Conservation Area Advisory Committee

Meeting Date : 4th of December 2017

Street Elevation (B2132) @ 1:200

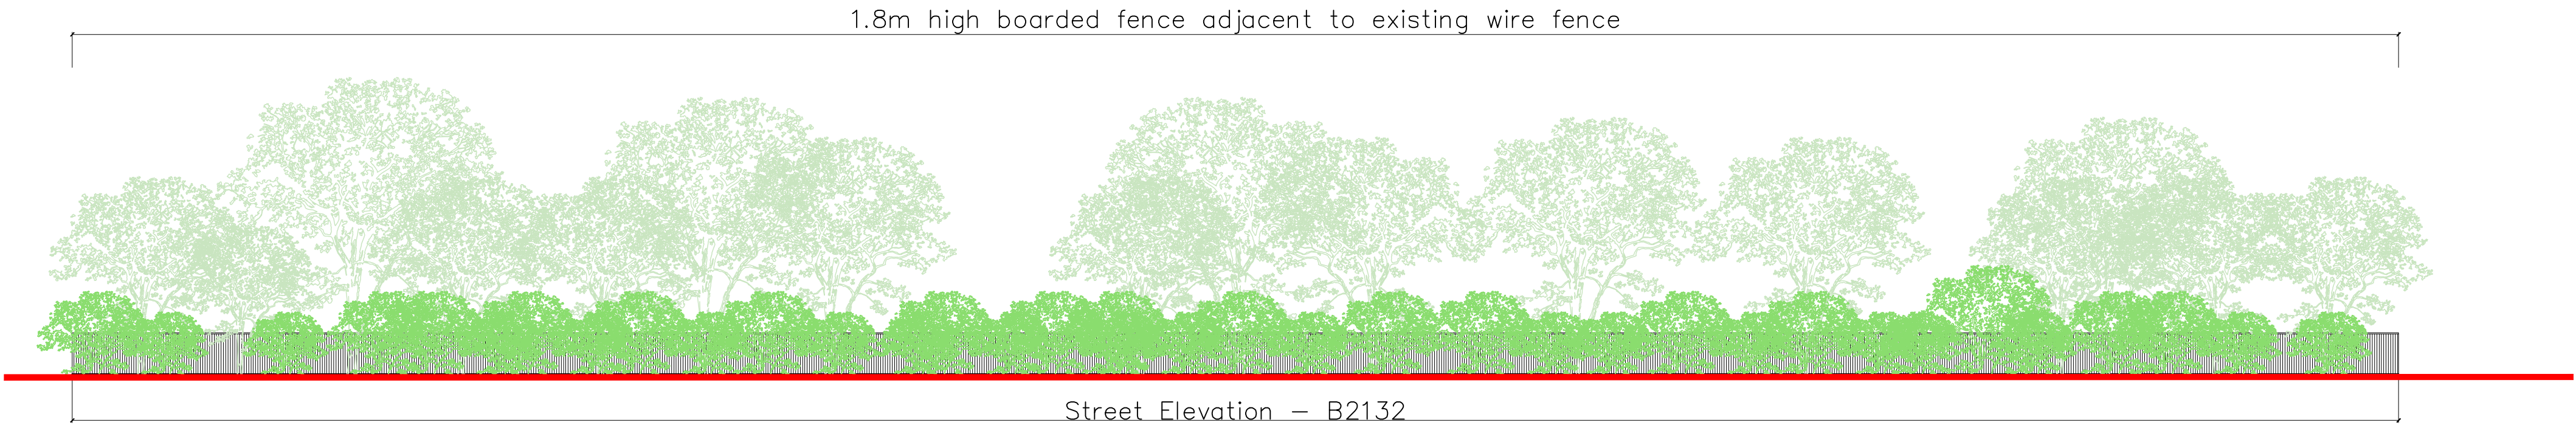
Ref	Description	Address	Design award
[REDACTED]			
Y/72/17/HH	Boundary fencing. This application affects Character & Appearance of the Main Road/Church Road, Yapton, Conservation Area.	Berri Court Main Road Yapton	
Comments:	<i>Objection</i> BN18 OED		
Suggested Conditions:	<i>Historic information regarding restoration of existing railway and road for new railway. Concern at any possible of railway. Also precise details of proposed fencing items to be established, also is agreed, shown in the area.</i> <i>For a conservation area.</i>
